KITITITAS COUNTY

DEPARTMENT OF PUBLIC WORKS

MEMORANDUM

SUBJECT: Bugni BL-19-00013 Public Works Review

**PART OF SECTION 3,  
TOWNSHIP 19 NORTH, RANGE 16 EAST, W.M.  
PROPOSED**

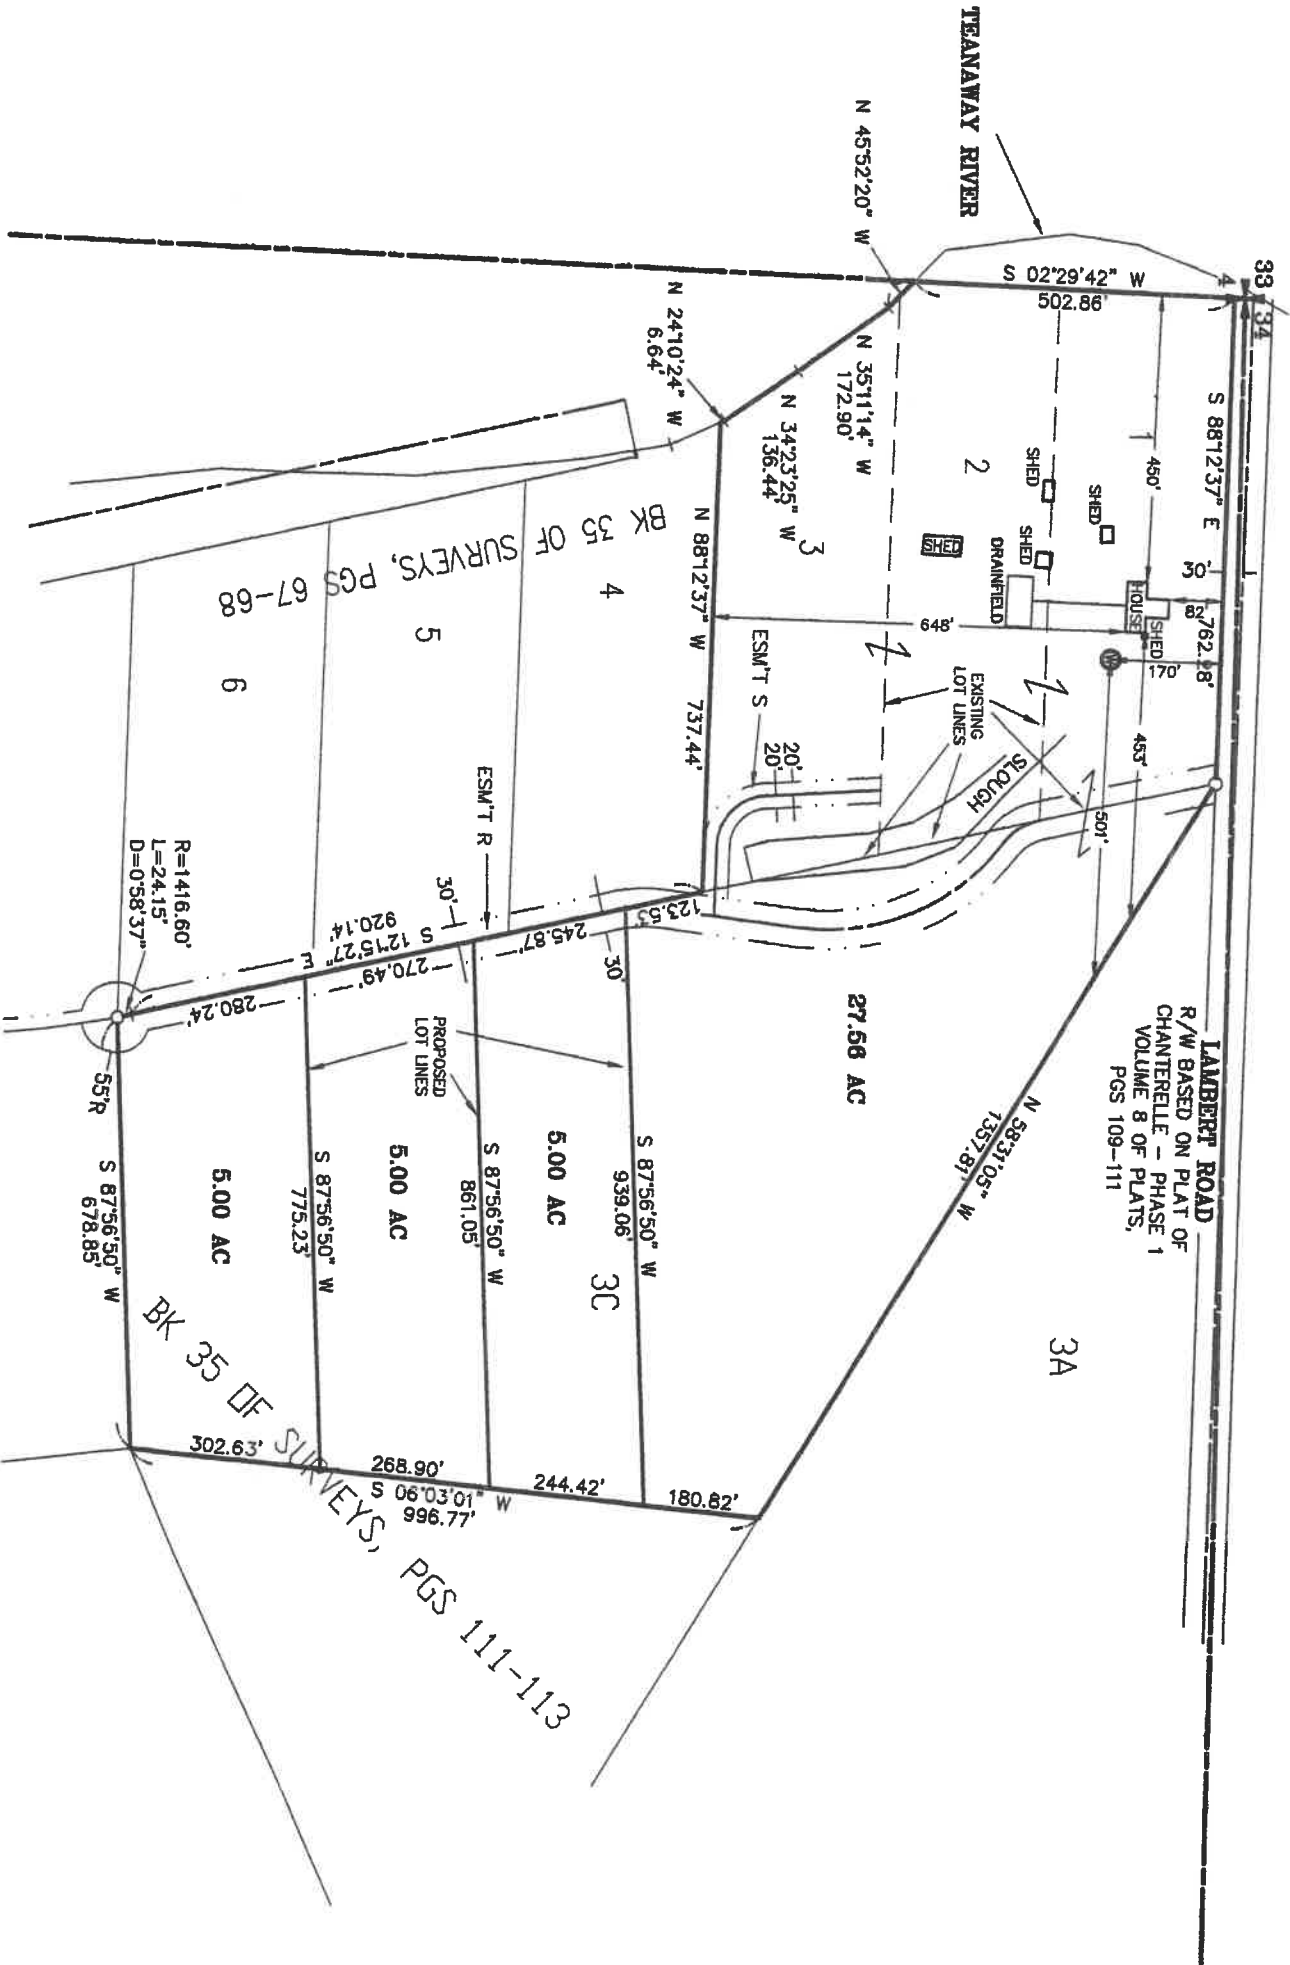
4. Private Road Improvements: Access Lambert Road shall be constructed as a Low-Density Private Road. See Table 4-4, current Kittitas County Road Standards, 12/15/15 edition.

- a. Access easements shall be a minimum of 60' wide. The roadway shall have a minimum width of 20', with 1' shoulders, for a total width of 22'.
 - b. Minimum centerline radius will be 60'.

- c. The surface requirement is for a minimum gravel surface depth of 6".

- d. Maximum grade is 10%.
 - e. Stopping site distance, reference AASHTO.
 - f. Maintenance of driveway approaches shall be the responsibility of the owner whose property they serve. The County will not maintain accesses.

- i. All easements shall provide for AASHTO radius at the intersection of county road.
 - j. A paved apron shall be constructed at the intersection of the proposed private intersection and the county road right of way.

5. Turnaround: A When a road extends more than 150' from the centerline of a County road or other publicly maintained road or serves more than three lots, a turnaround shall be provided. The turnaround shall be a cul-de-sac for roads serving five or more lots/units. The turnaround may be a hammerhead for roads serving four or less lots/units or for a land use development activity occurring prior to the end of the road. Cul-de-sac and hammerhead designs must conform to the specifications of the International Fire Code. A cul-de-sac shall have an easement diameter of at least 110 feet and a driving surface of at least 96 feet in diameter.
